RE: Advice on the “Response to Submissions” to Secondary Innovation Precinct (SSD-79146716)

Thank you for the opportunity to comment on the Response to Submissions (RtS) for State Significant Development (SSD-79146716) for Pymble Ladies Collage – Secondary Innovation Precinct at 20 Avon Road, Pymble.

Following a review of the revised documentation, Council maintains its **objection** to the proposed development. Council’s submission is contained in **Attachment 1**.

SITE PLAN - PROPOSED

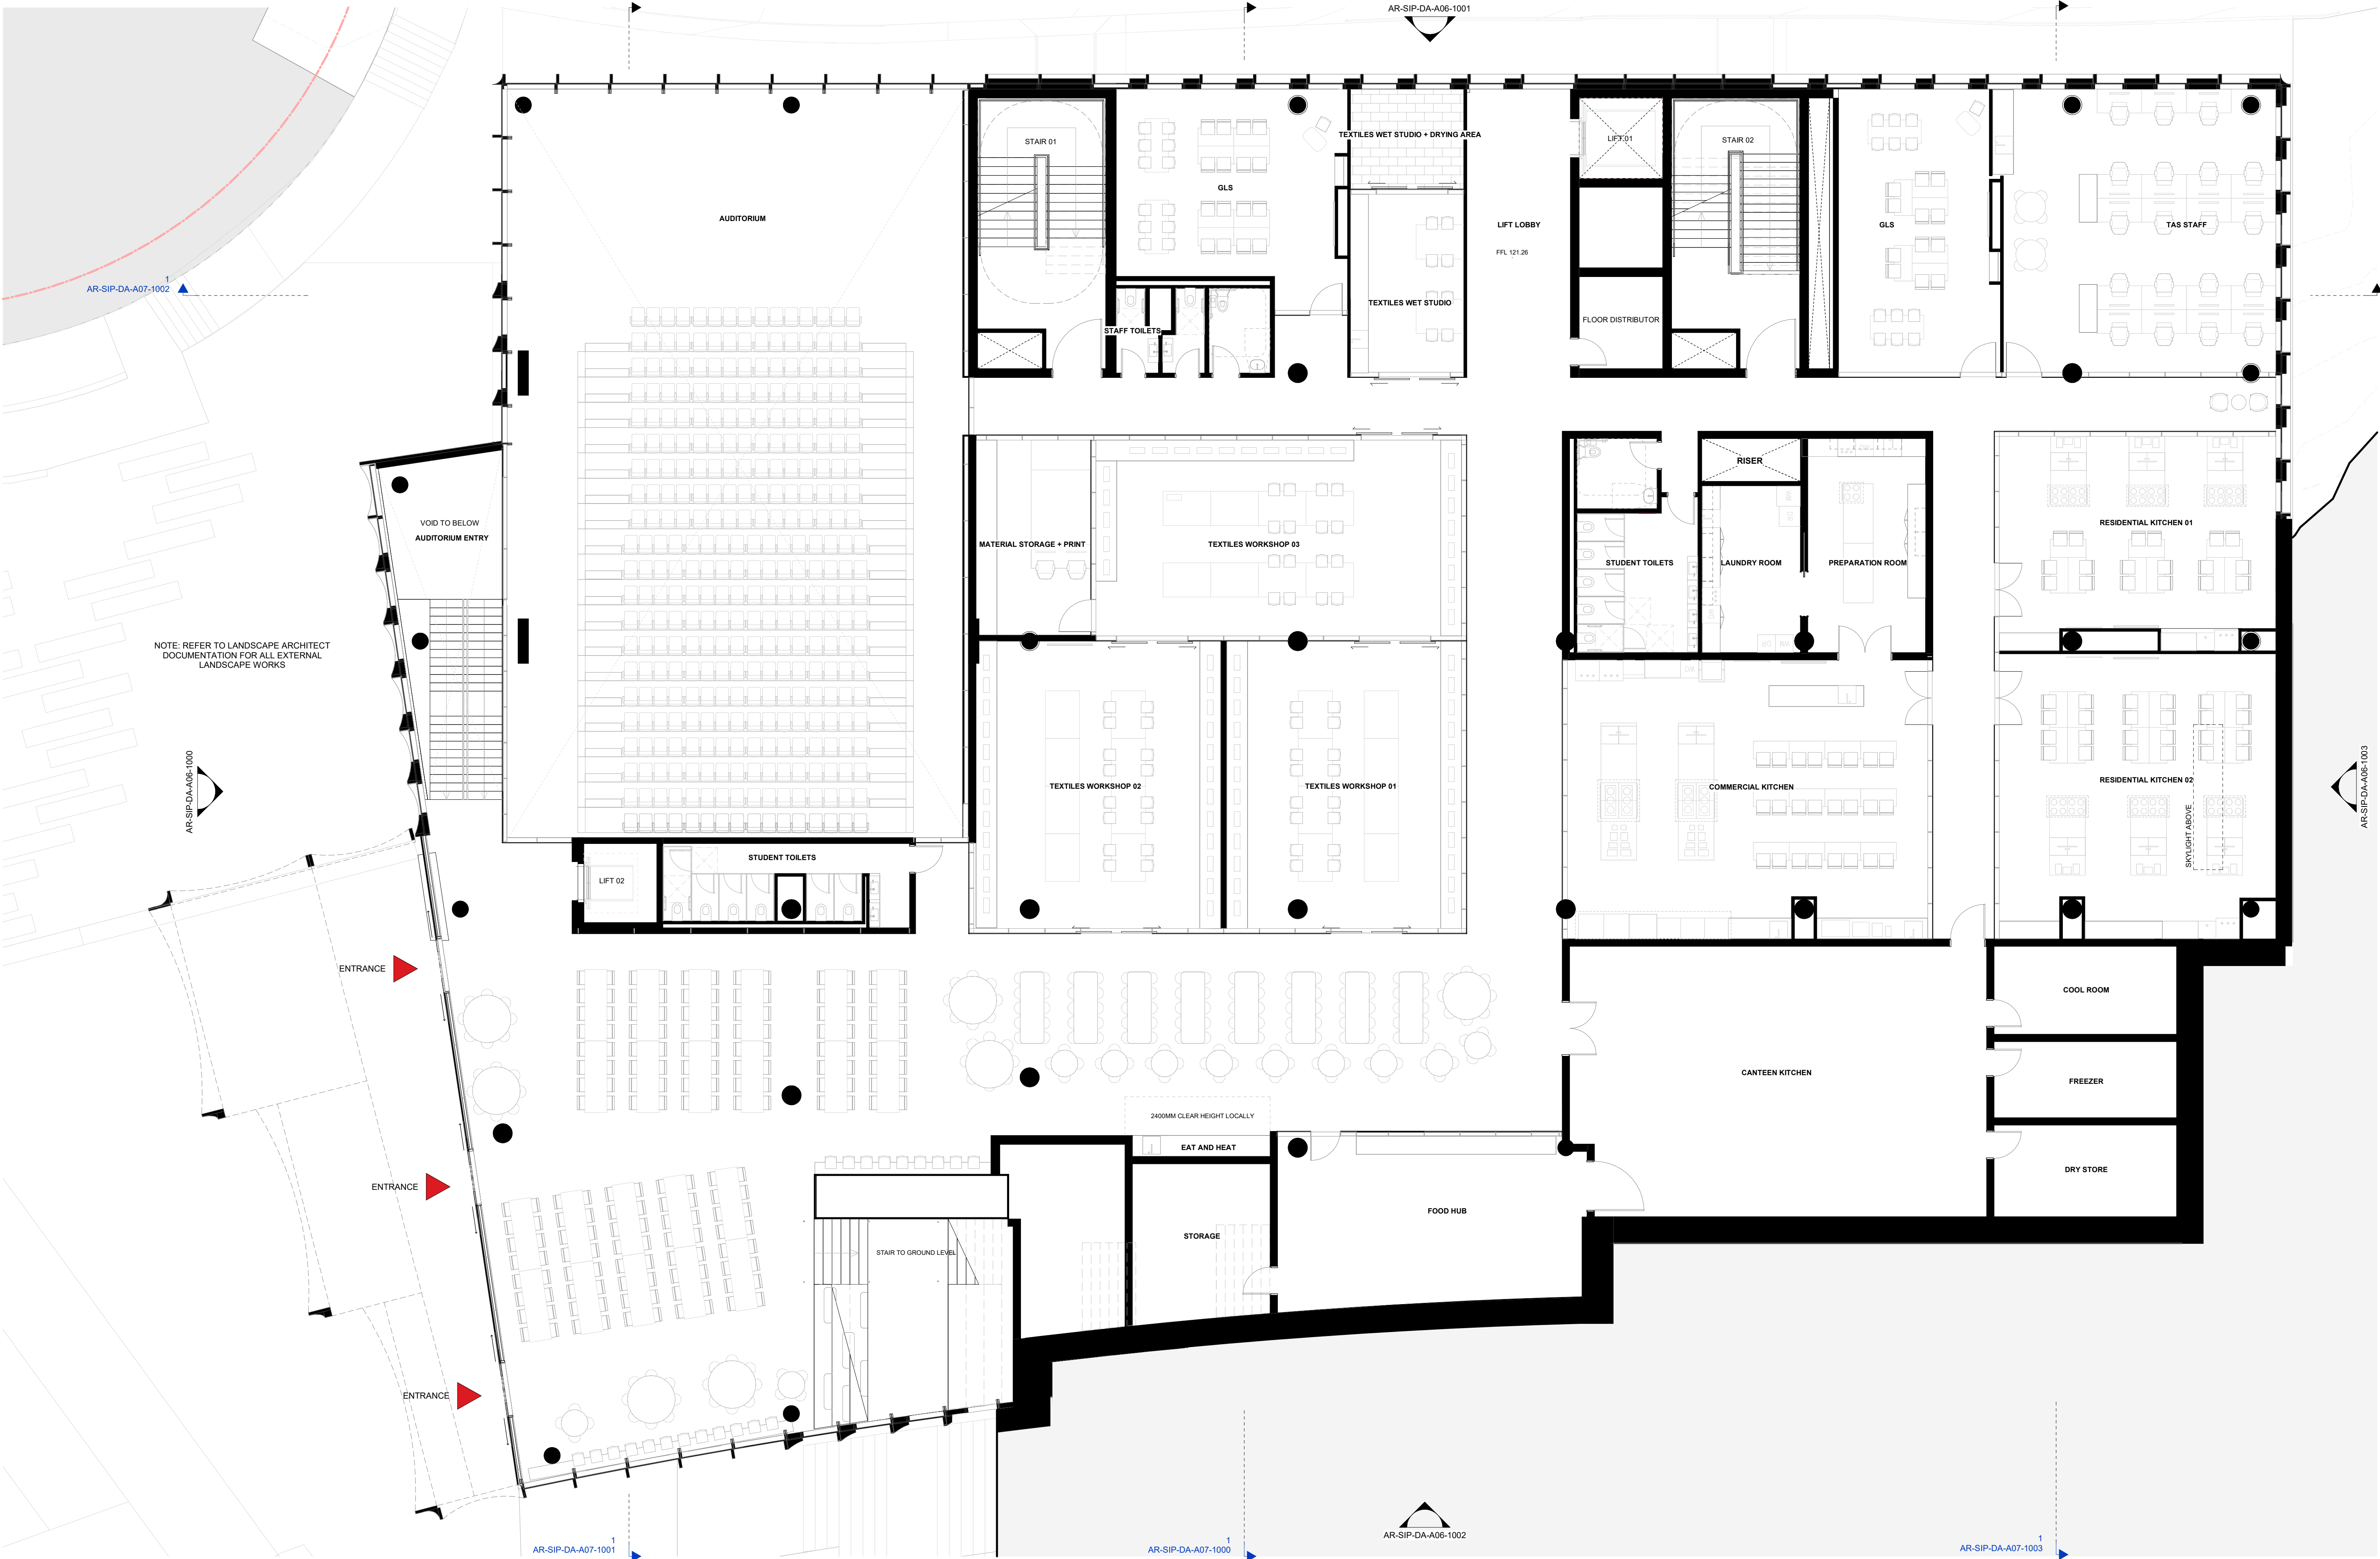
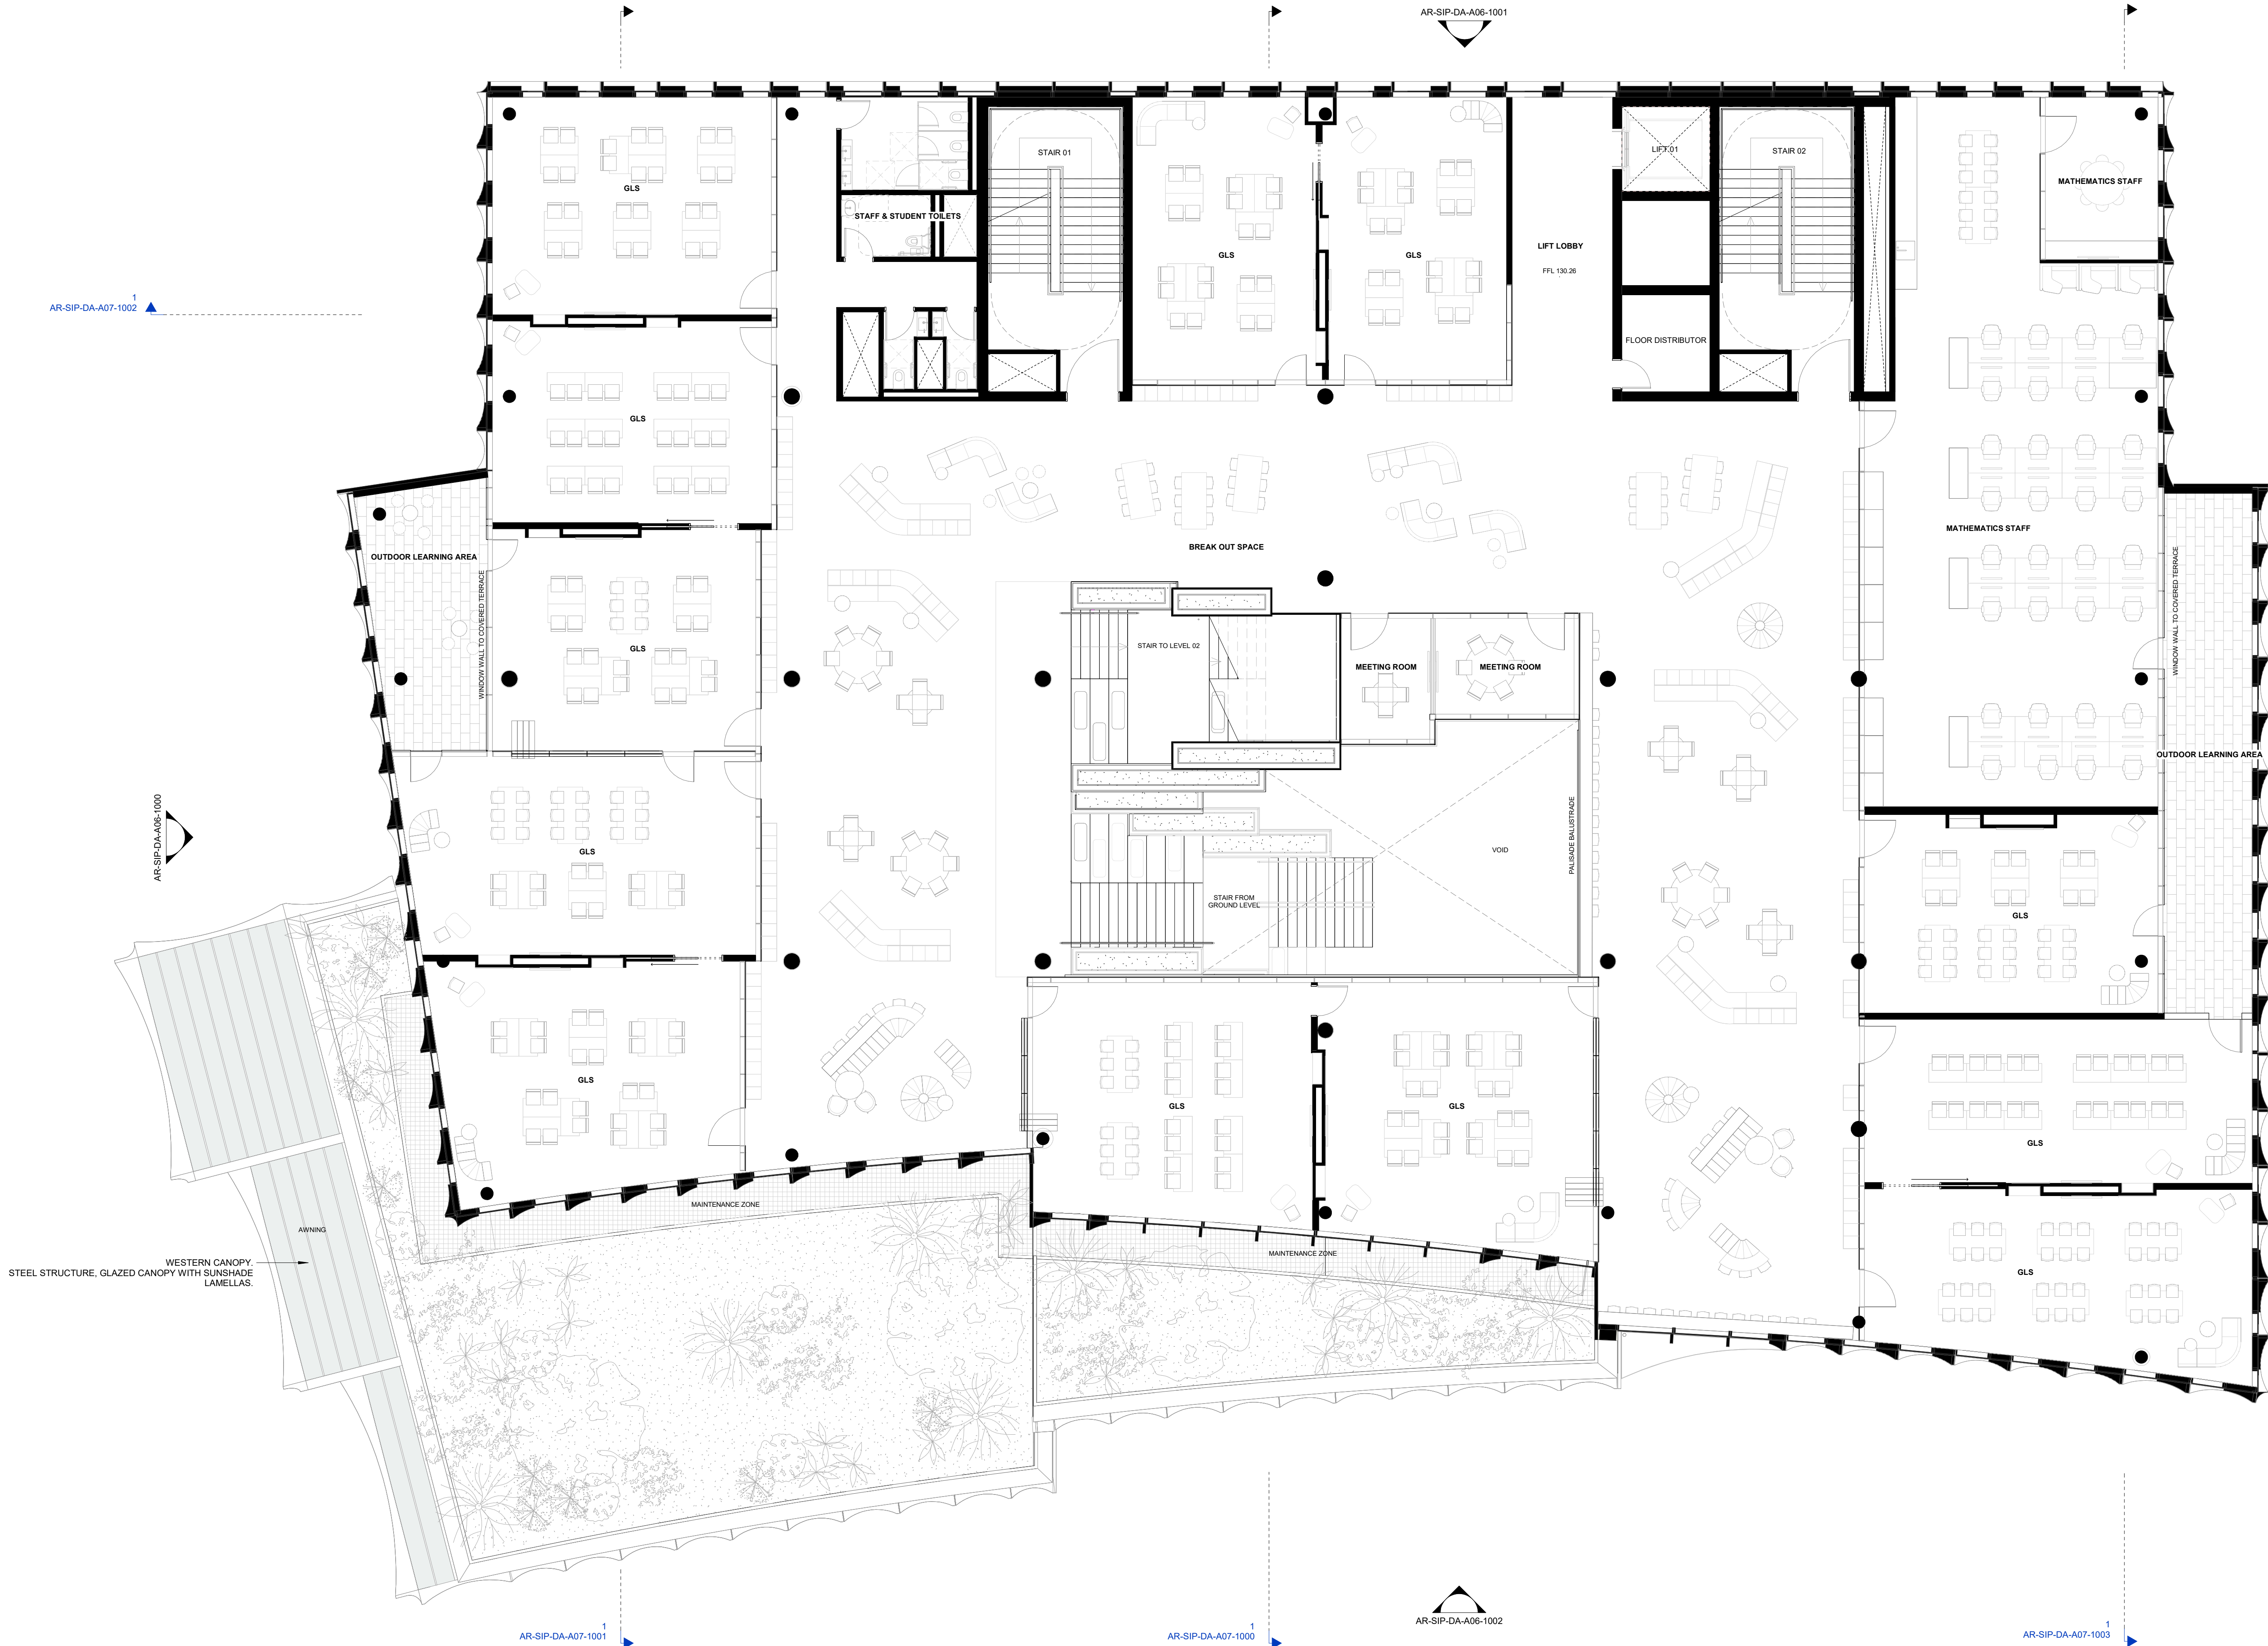
The western front corner of the proposed SIP building is setback 40 metres from the north-western boundary (Avon Road frontage), which is consistent with the setback of the north-eastern front corner of the existing Science Building (refer to Figure 1). The Science Building adjacent to the proposed SIP building is highly visible from Avon Road (refer to Figure 2). While trees within the proposed 'Lower Riparian Zone' are to be retained, the visual impact of the proposed development should not rely on vegetation for screening. As such, concerns remain regarding the lack of articulation or modulation to reduce its visual bulk on the northern façade of the six-storey building, which fronts Avon Road and adjacent R2-zoned low density residential dwellings along Avon Road.

- i. Arborist report (Appendix R) has addressed Council concerns related to the trees proposed to be retention.
- ii. All *Ligustrum sinesnis*, are now shown for removal.
- iii. Several significant indigenous trees are still proposed for removal to allocate the proposed structures. The following trees are of high retention value, indigenous or native and located in the margins or adjacent to the proposed structures; these trees could be retain with a redesign of the proposal: T61, T71, T85, T102, T128, and T129.
